Parcel# 5519401031

Owner:
FAUSON DOLORES V

Location:
809 CARDINAL ST

Owner:
FAUSON DOLORES V

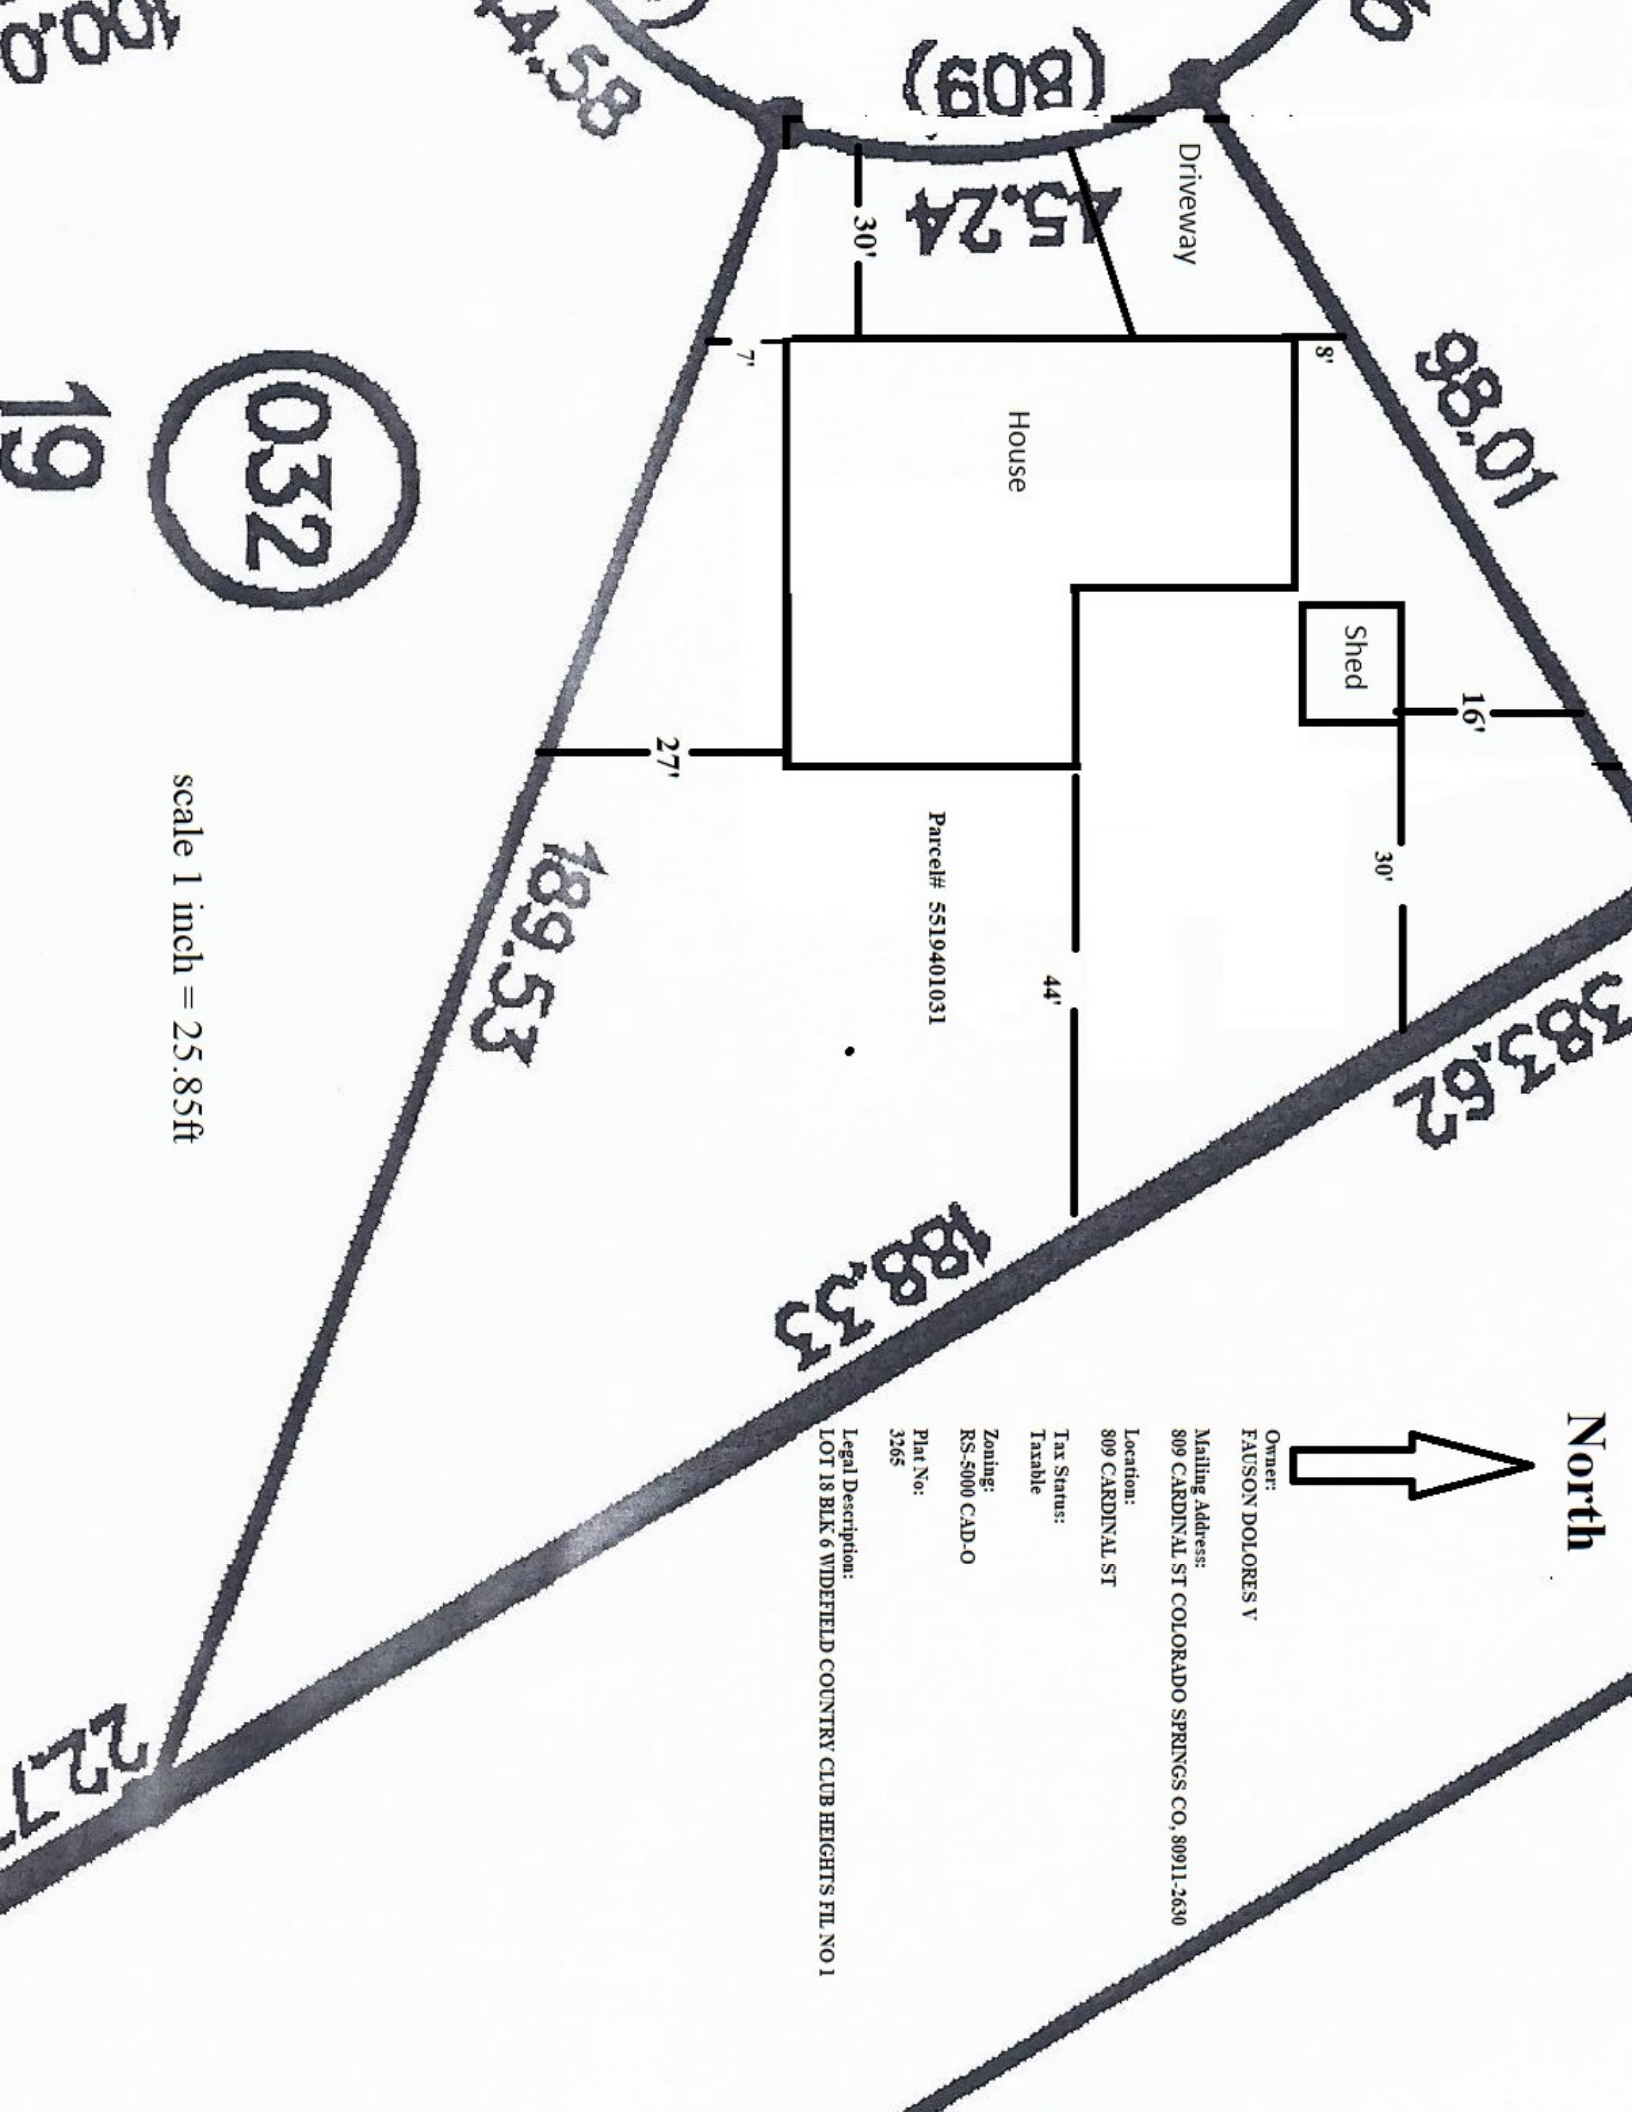
Please add the following to the site plan:
 -Owner contact telephone number and email for responsible party
 -Property tax schedule number (5519401031)
 -Lot size (12900 SQFT)
 -Lot area coverage calculation
 -The footprint of all existing and proposed buildings
